# CITY OF ALBUQUERQUE

January 6, 2016

**RE: Heritage Market Place  
1820 Unser Blvd NW  
Requested for 30 Day Temporary C. O. - Accepted  
Engineers Stamp Date 3/25/15 (H09D024)**

GRADING AND DRAINAGE PLAN

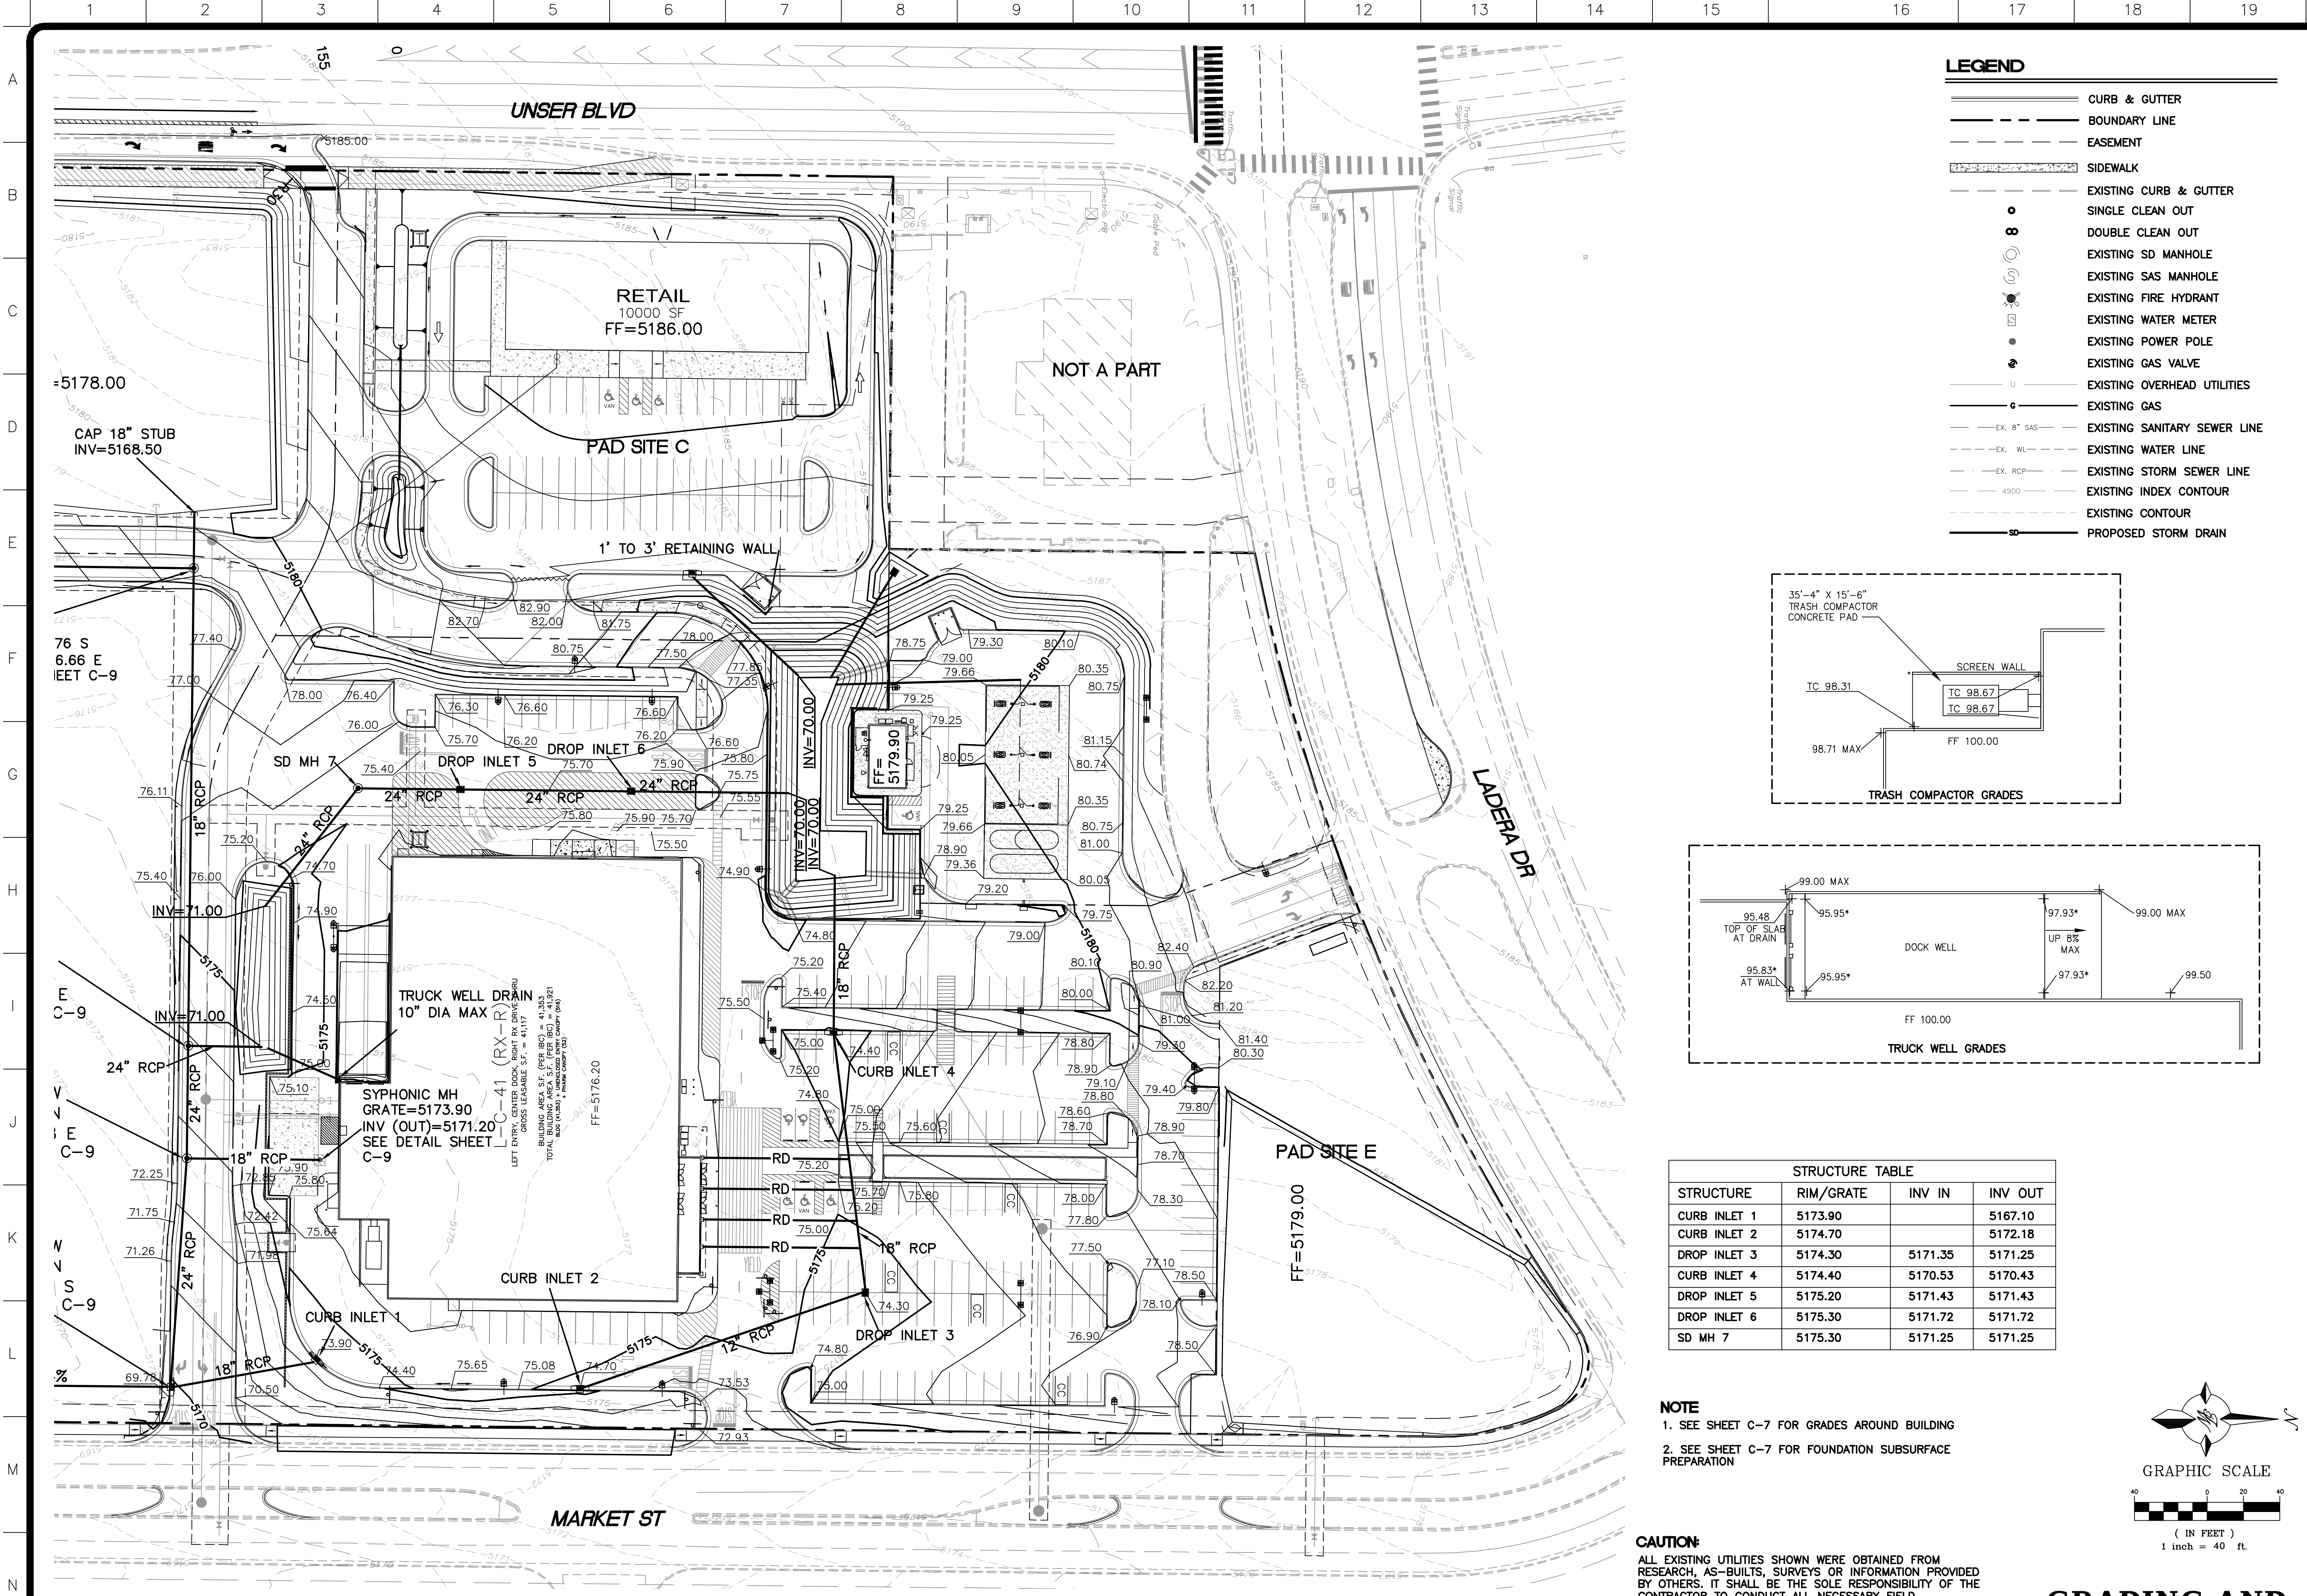
- All of the filter covers need to be removed from the drop inlets and curb inlets.

An inspection by our office will need to take place after these corrects are made.
